#### Pacific Brook Christian School (SSD 16858710) – Review of Environmental Impact Statement

I refer to your e-mail dated 17 November 2021 in which the Planning and Assessment Division (P&A) of the Department of Planning, Industry and Environment (the Department) invited Biodiversity and Conservation Division (BCD) to provide advice in relation to the Pacific Brook Christian School project (SSD 16858710) in Muswellbrook.

# Pacific Brook Christian School Project (SSD 16858710) – Review of EIS

Figure 8: Hazard Categorisation (1% AEP) 2019 FRMS&P

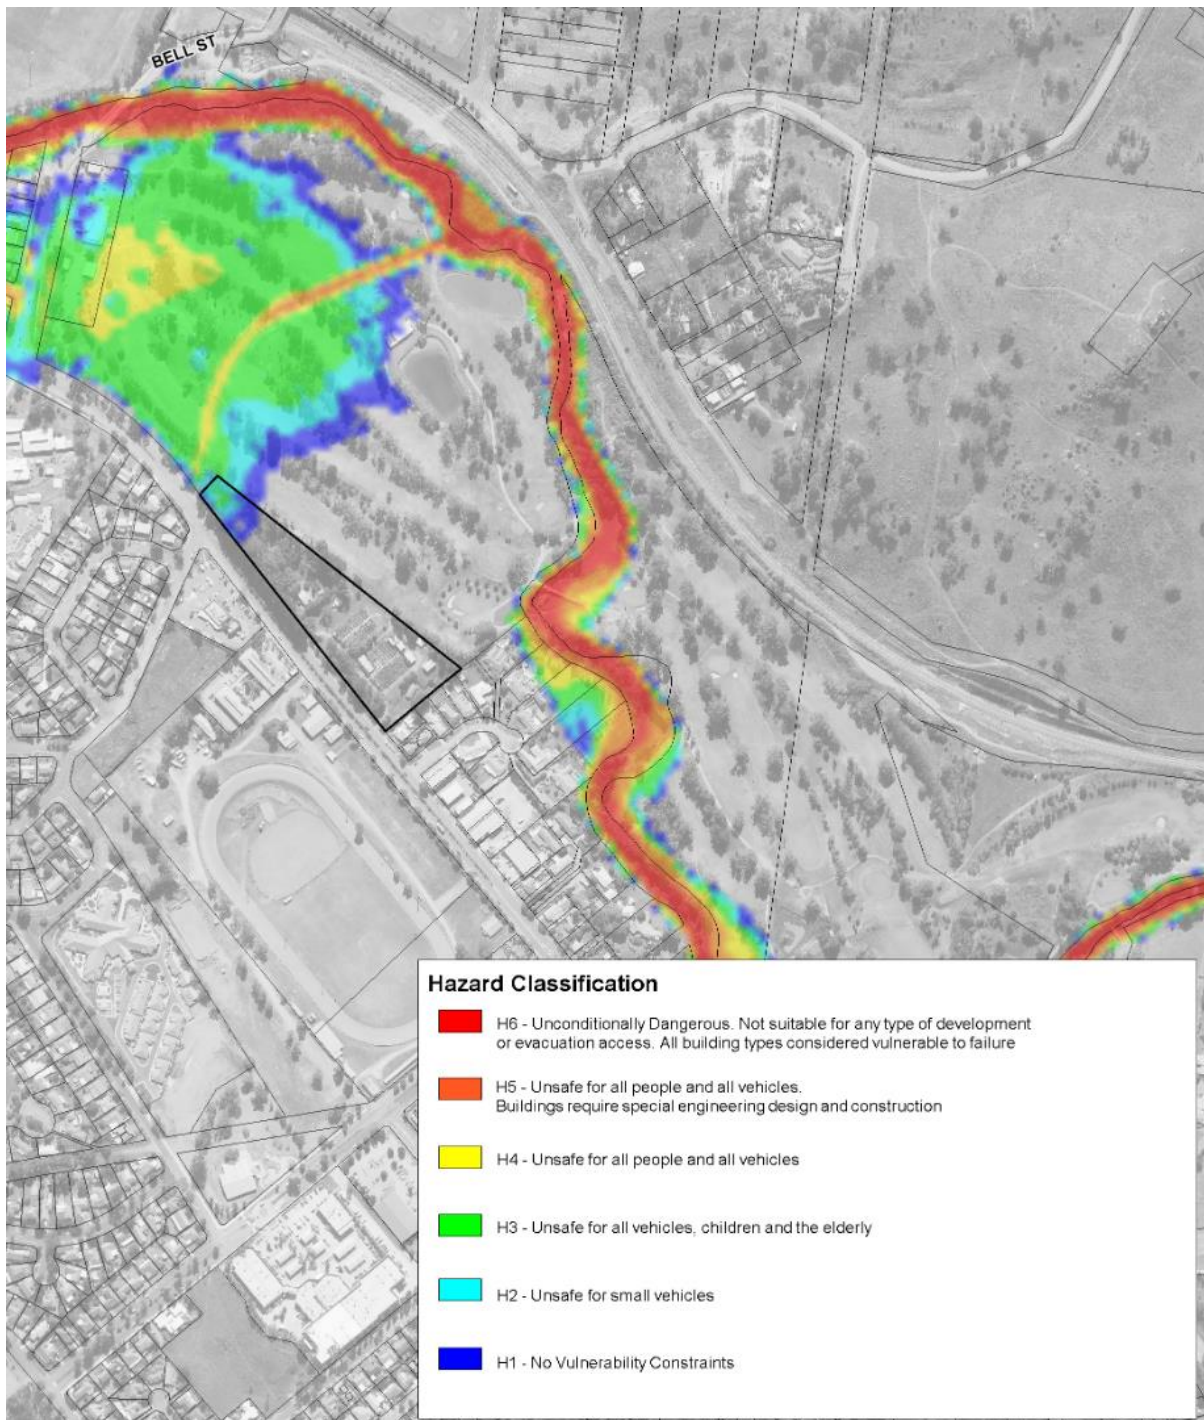
Figure 6 'Design Flood Levels (RHDHV, 2019) – Long Section' shows a local depression at chainage 200 m with an elevation of 148.5m. Figure 8 'Hazard Categorisation (1% AEP) 2019 from S&P' shows the elevation, immediately upstream on Muscle Creek is 148.92m AHD. This suggests that a breakout of Muscle Creek commences in floods with an AEP greater than 1%. This secondary flow path would originate near St Andrews Place (location 3) and flow through the subject site along the local depression, identified in Figure 8. However, no such flow path has been identified in the FIA.

The existence of a secondary flow path through the site would likely mean that the FIA is underestimating the flood planning levels and flood affectation across the site. It would also impact on emergency management.

More detailed topographical information is required to determine if a secondary flow path through the site exists.

BCD recommends that an additional survey is required to determine if there is a secondary overland flow path through the site. If a flow path is identified, then the flood impact assessment will need to be updated to determine:

- new flood planning level for the development.
- impacts of filling the secondary flow path
- impacts on emergency management.

Figure 10: Difference in 1% AEP peak flood level between existing and proposed scenarios

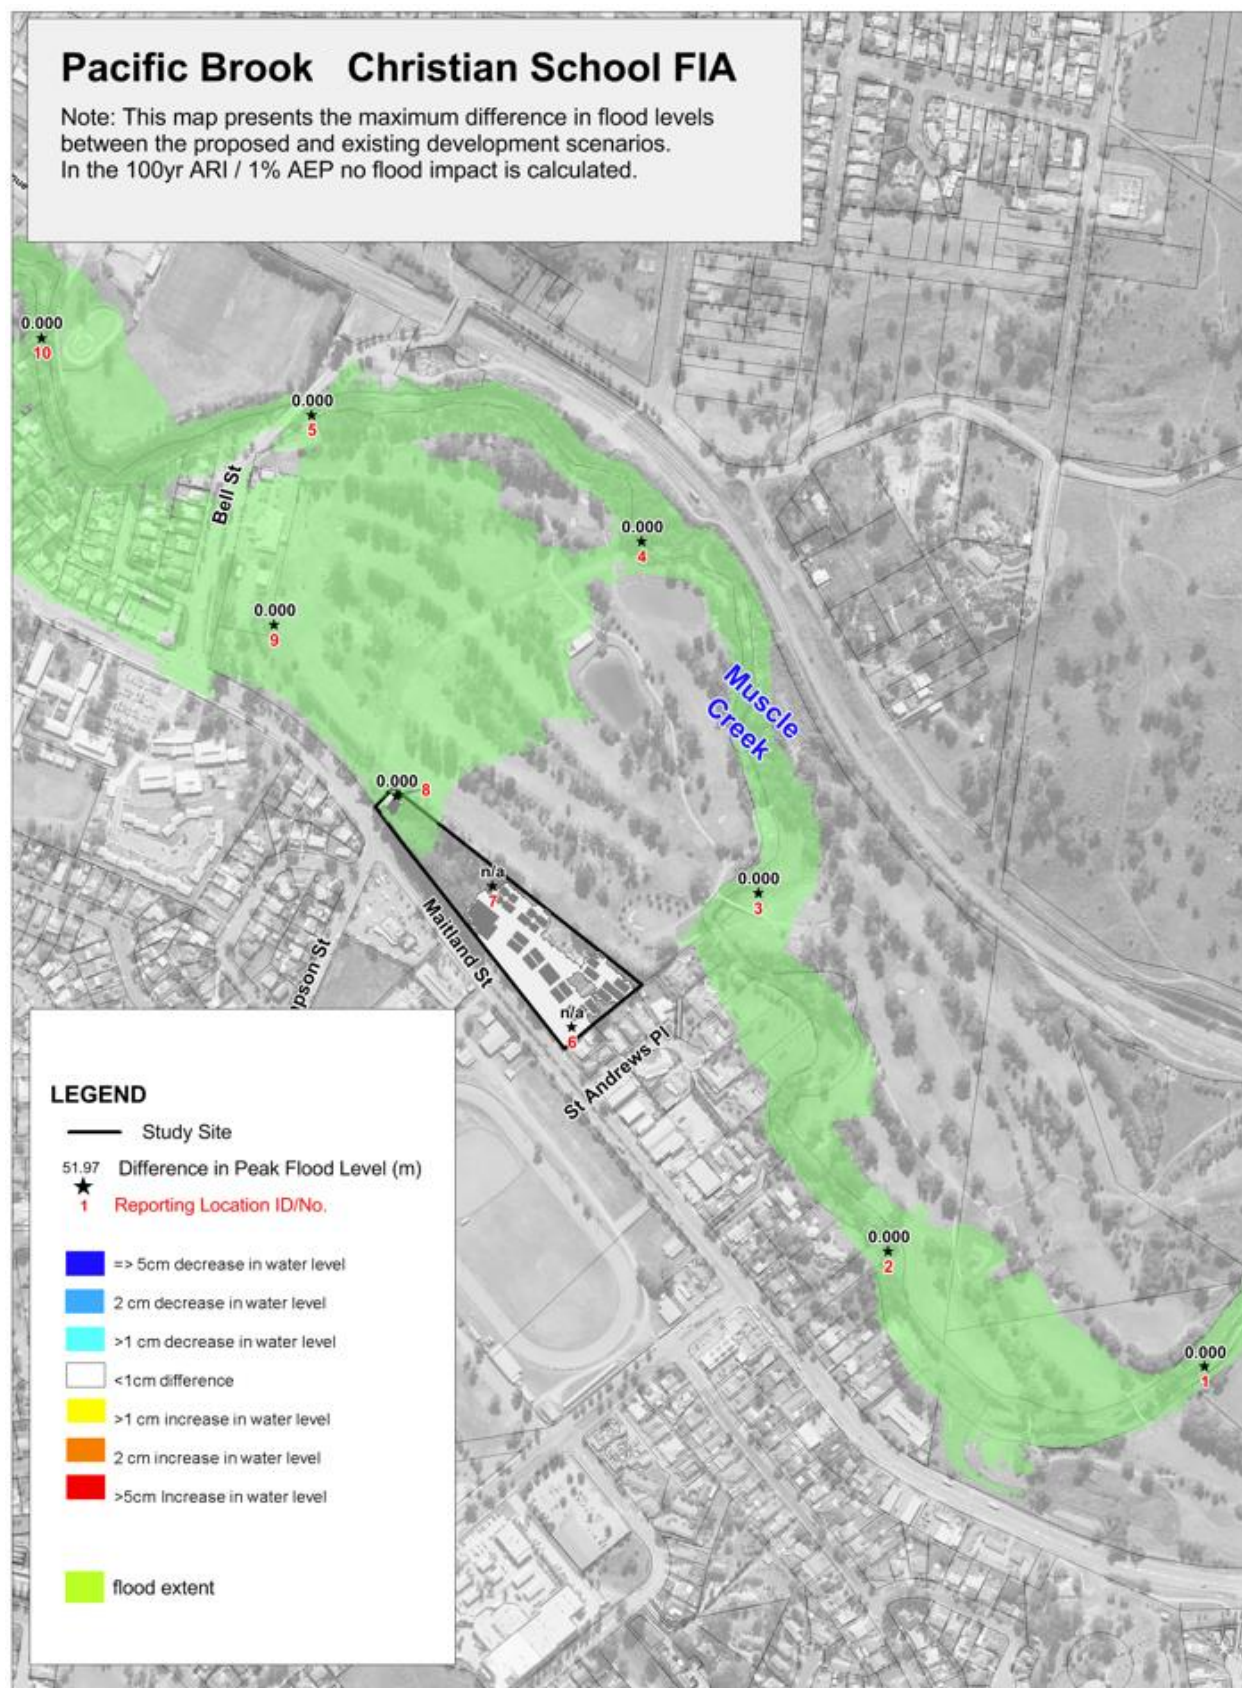
The FIA estimates that the development will increase 1% AEP flood levels at point 6 by 77mm. Point 6 is within the subject site but is very close to the residential properties on St Andrews Close. BCD considers that the maximum tolerable afflux for a development of this type is 10mm. Consequently, further assessment is required to determine the flood afflux along St Andrews Close and how these impacts could be mitigated. If the proponent considers that achieving a maximum afflux of 10mm is not possible or practical then affluxes up to 50mm can be considered for major projects, provided the impacts are well understood and appropriately justified. Any justification will need to:

BCD recommends that the maximum allowable off-site increase in 1% AEP flood levels for residential properties is 10mm. If achieving a maximum afflux of 10mm is not practical then affluxes up to 50mm can be considered for major projects, provided the impacts are well understood and appropriately justified.

STORMWATER TREATMENT PIT DETAIL
N.T.S.

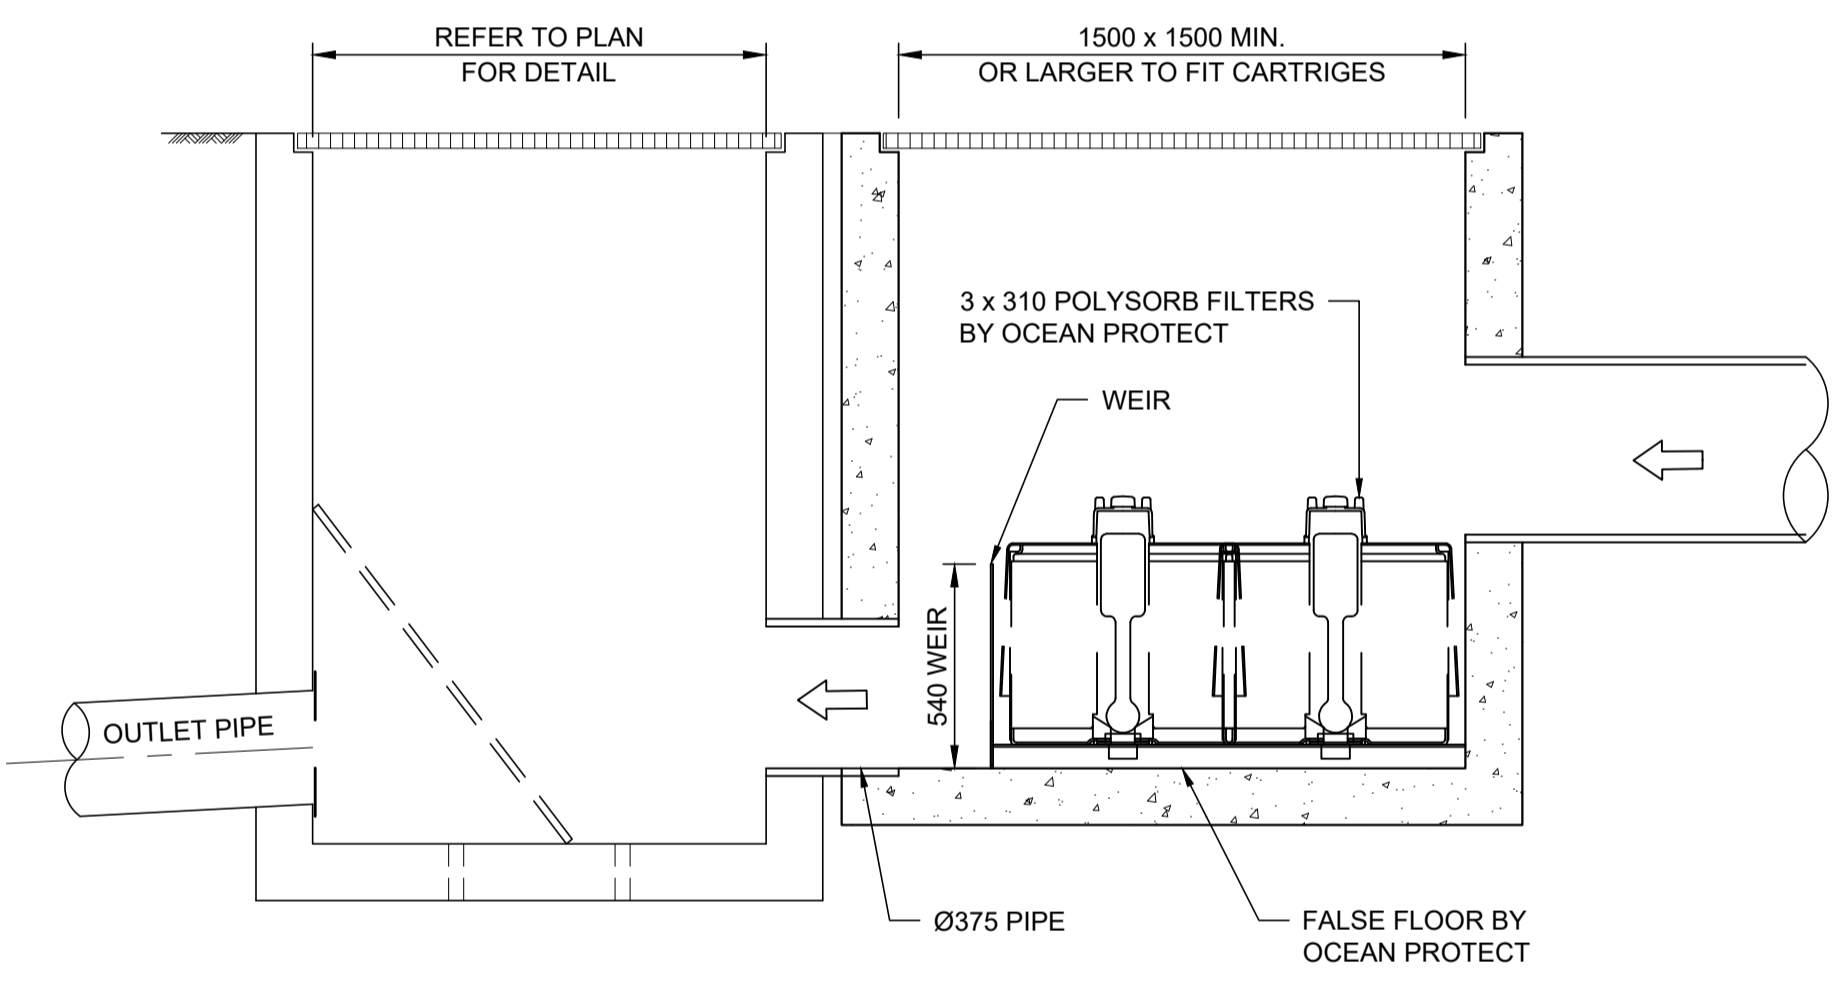
The stormwater quality treatment design should be changed to incorporate WSUD features instead of the proposed proprietary inserts. The proposed stormwater strategy, Appendix 36A to the EIS, includes modelling and plans to achieve the required pollution reduction targets consistent with development. This is achieved using proprietary pit inserts such as Oceanguard and Polysorb cartridges. Proprietary treatment is generally used in city developments where it is not possible to use water sensitive urban design pollution treatment due to significant site constraints. However, the school is in a rural township with ample land available.

BCD considers it likely that proprietary pit inserts will be removed as part of maintenance activities and the projected pollution reduction targets no longer achieved. Contractors in rural areas are not typically experienced in maintaining and replacing propriety provision pit insert cartridges, and are familiar with standard WSUD stormwater treatment devices, which also serve as landscaping features.

BCD advises that proprietary stormwater quality inserts are not appropriate for this proposal. And the design of pollution control should be changed to incorporate WSUD features instead of the proposed proprietary inserts. If the proponent determines that proprietary inserts are the best solution, then the proponent must prepare a detailed maintenance plan and covenant that requires the inserts to be retained in a workable form for the life of the development.
